City of Albuquerque

RE: APARTMENT COMPLEX (L-19/D53)
(309 Tennessee SE)
ENGINEERS CERTIFICATION FOR CERTIFICATE OF OCCUPANCY
ENGINEERS STAMP DATED 11/3/1994
ENGINEERS CERTIFICATION DATED 2/18/2002

**Re: Apartment Complex – 309 Tennessee SE, Grading and Drainage Plan
Engineer's Stamp dated 11-3-94 (L19/D53)**

RE: APARTMENT COMPLEX (L19-D53). DRAINAGE PLAN FOR
BUILDING PERMIT APPROVAL. ENGINEER'S STAMP DATED JUNE 25, 1999.

FILE: 461
DATE: NOV. 3, 1994
REV MAY 1999
SHEET 1 OF 1

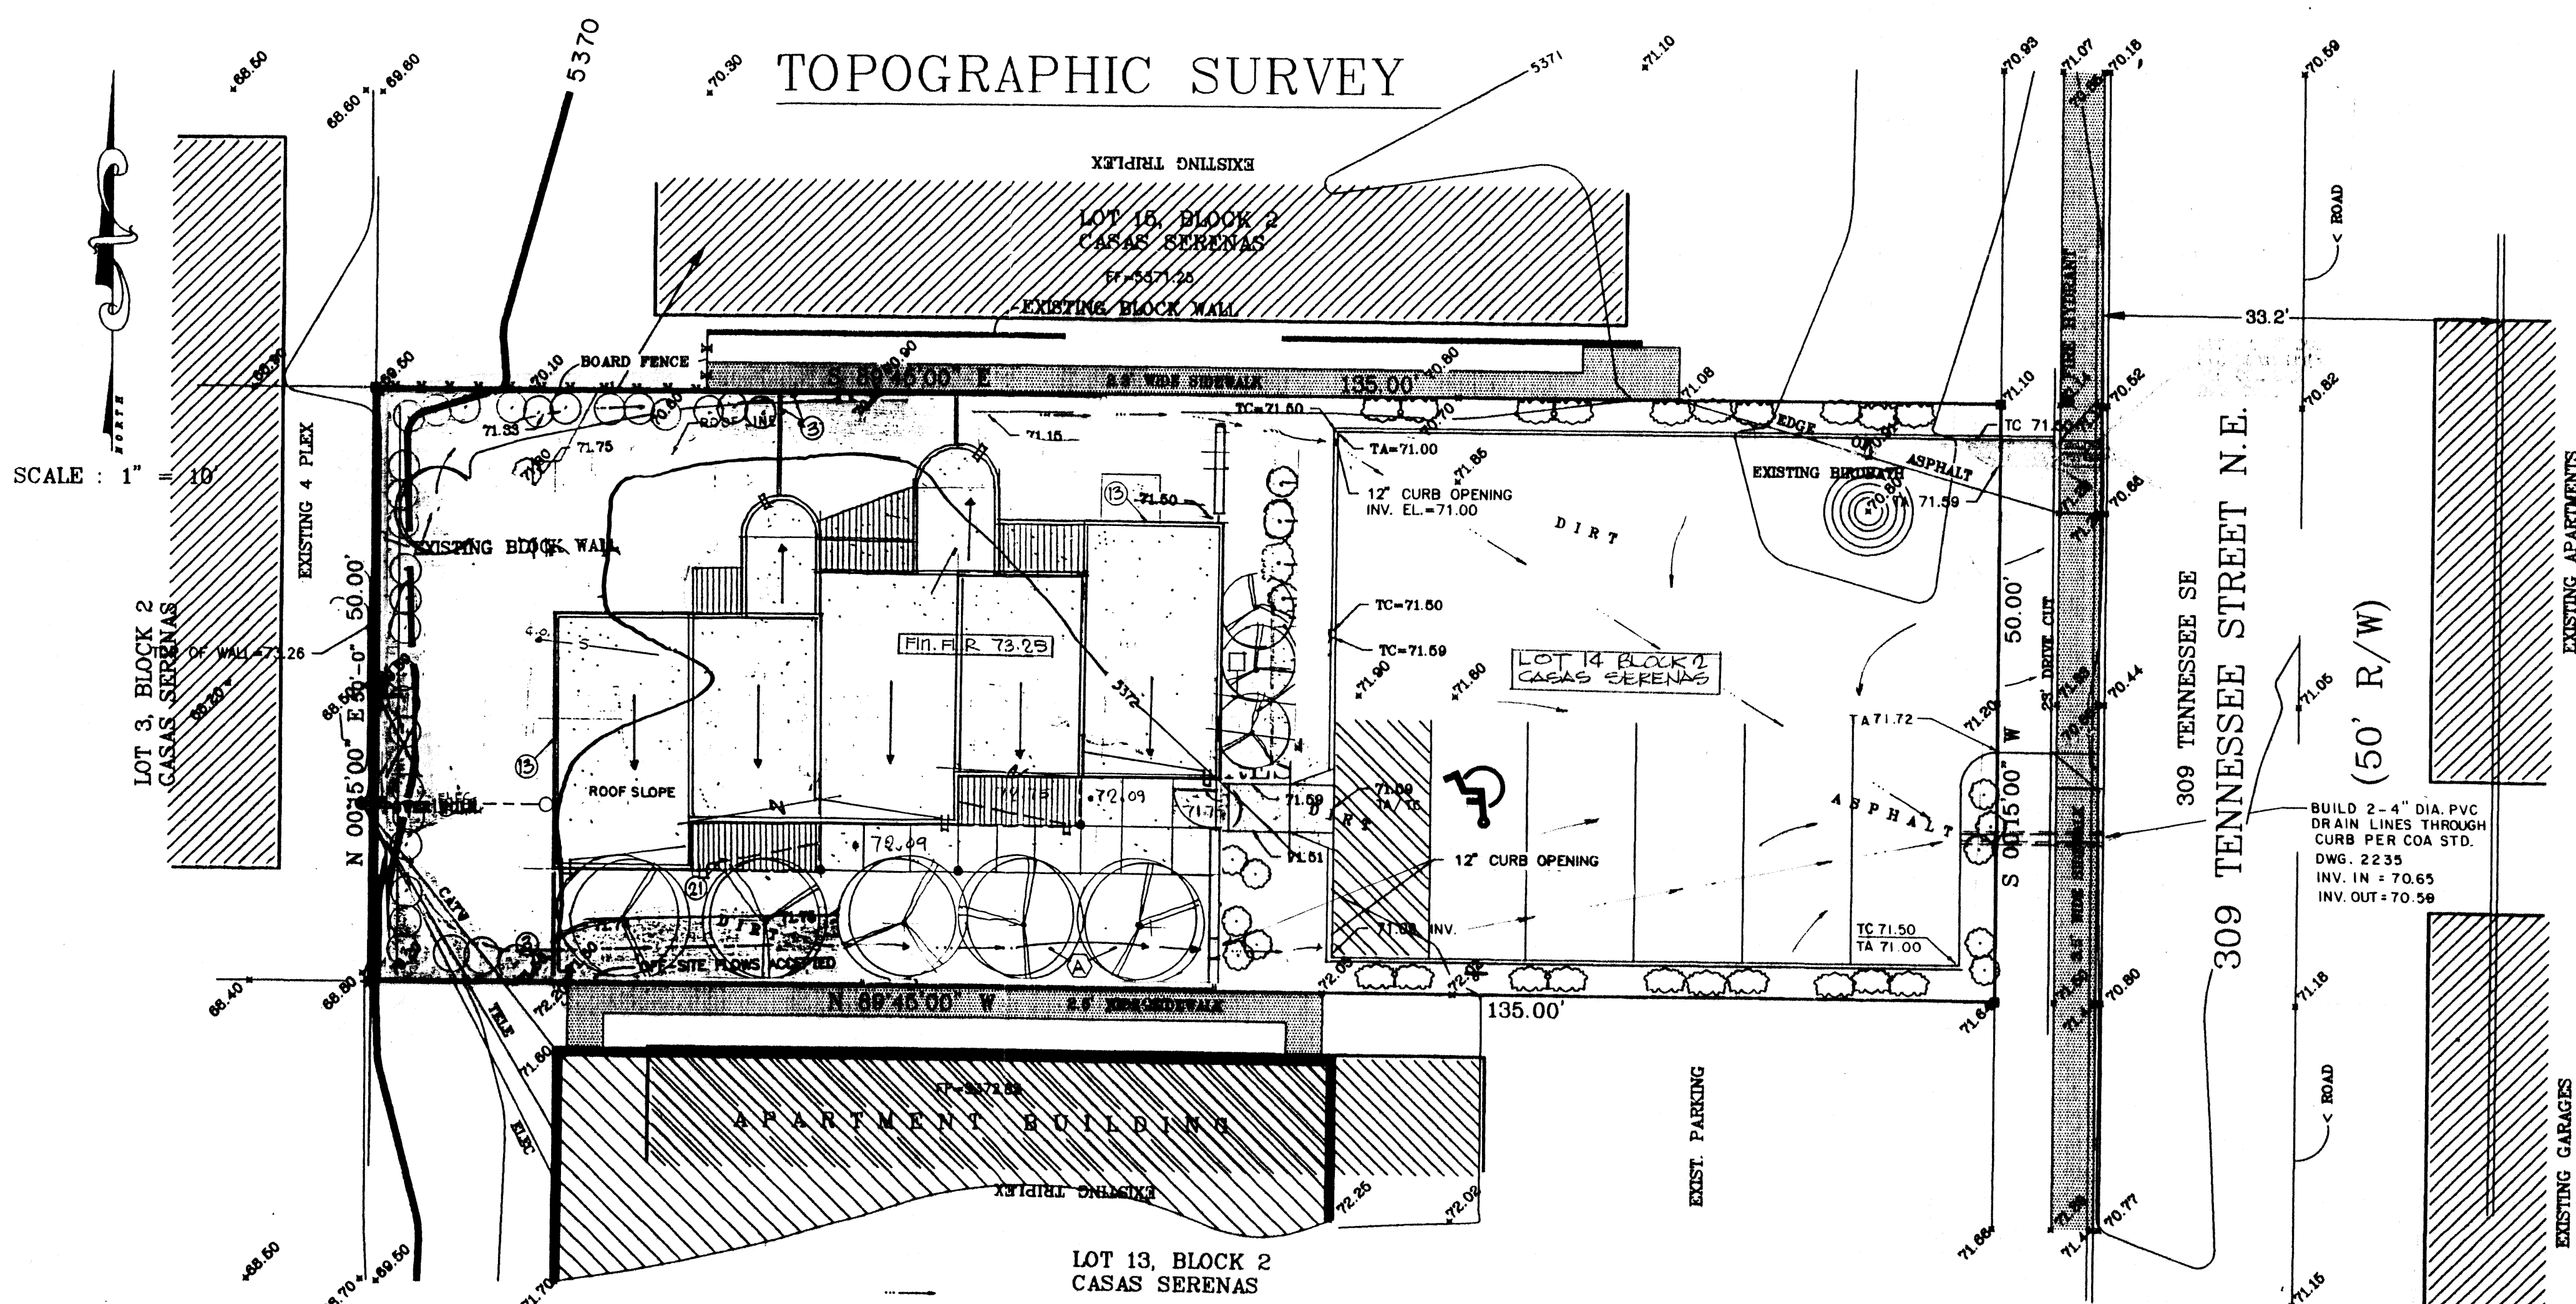
Please clarify that Tennessee Drive will drain continuously from south to north. According to the spot elevations along the flowline of the gutter, the culvert discharge will pond at the low spot shown at elevation 70.44 feet and will create a puddle in front of the driveway. Also, be sure to maintain a minimum slope of one-half percent around the proposed building to drain to the parking lot.

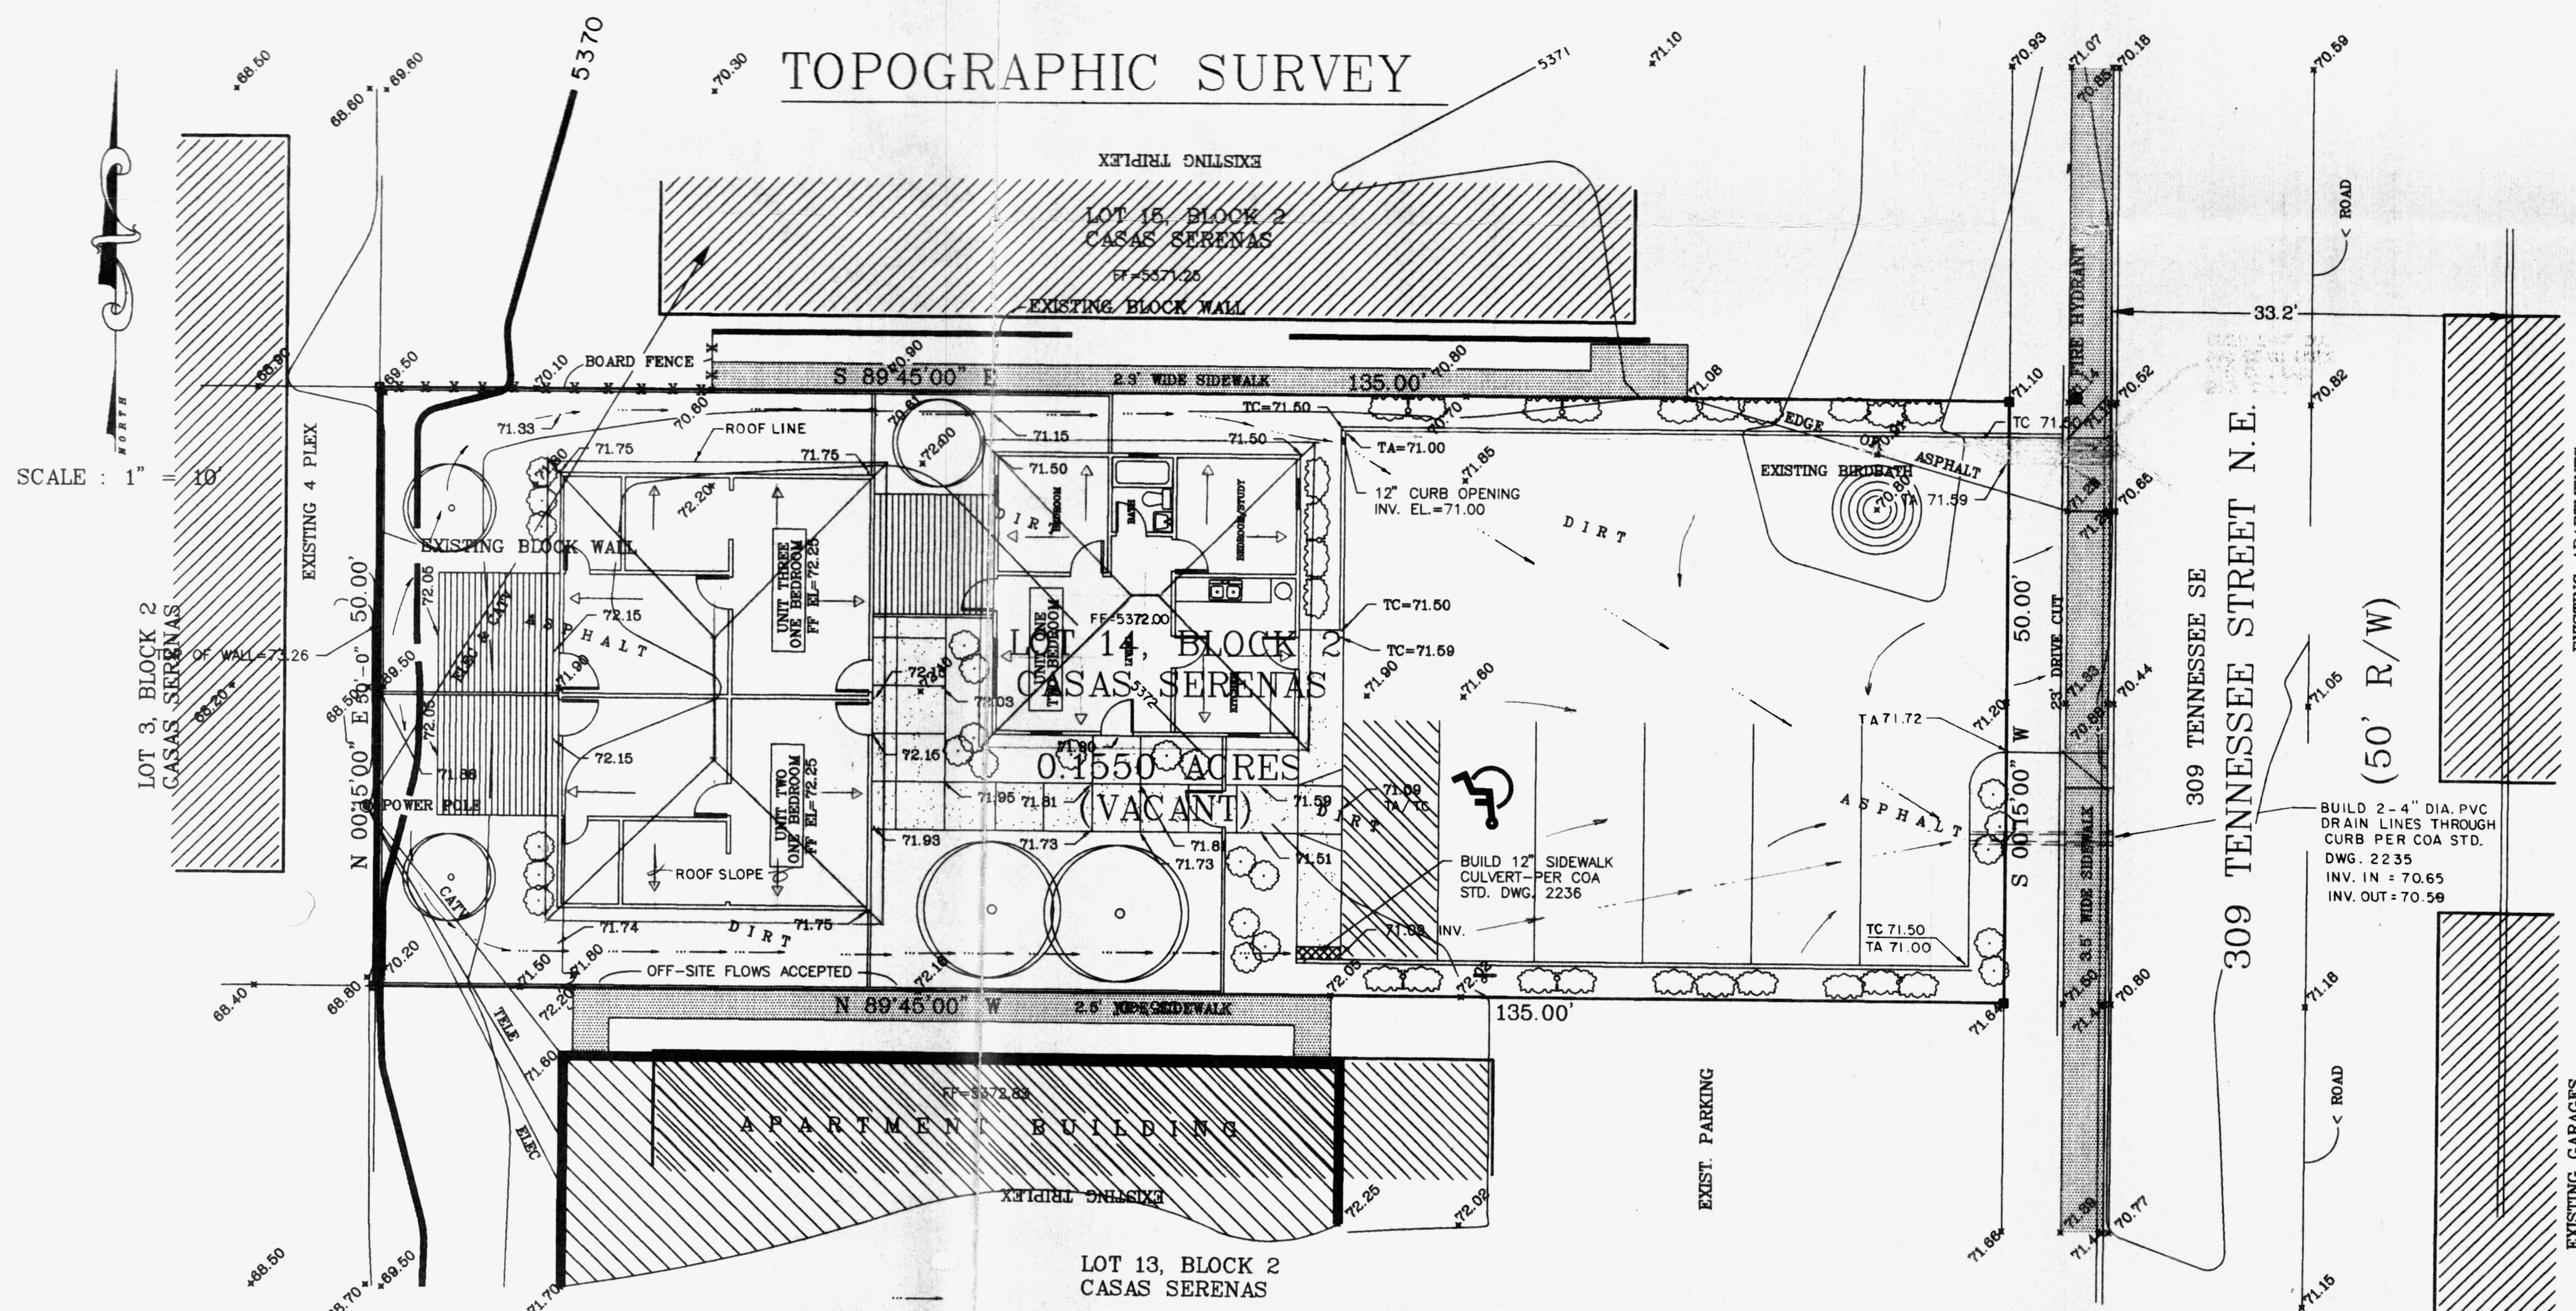
1. Proposed swale on the north side of building is about or
less than the required 1/2% slope.
2. Provision must be made to allow free flow within the swales
without fence obstructions.
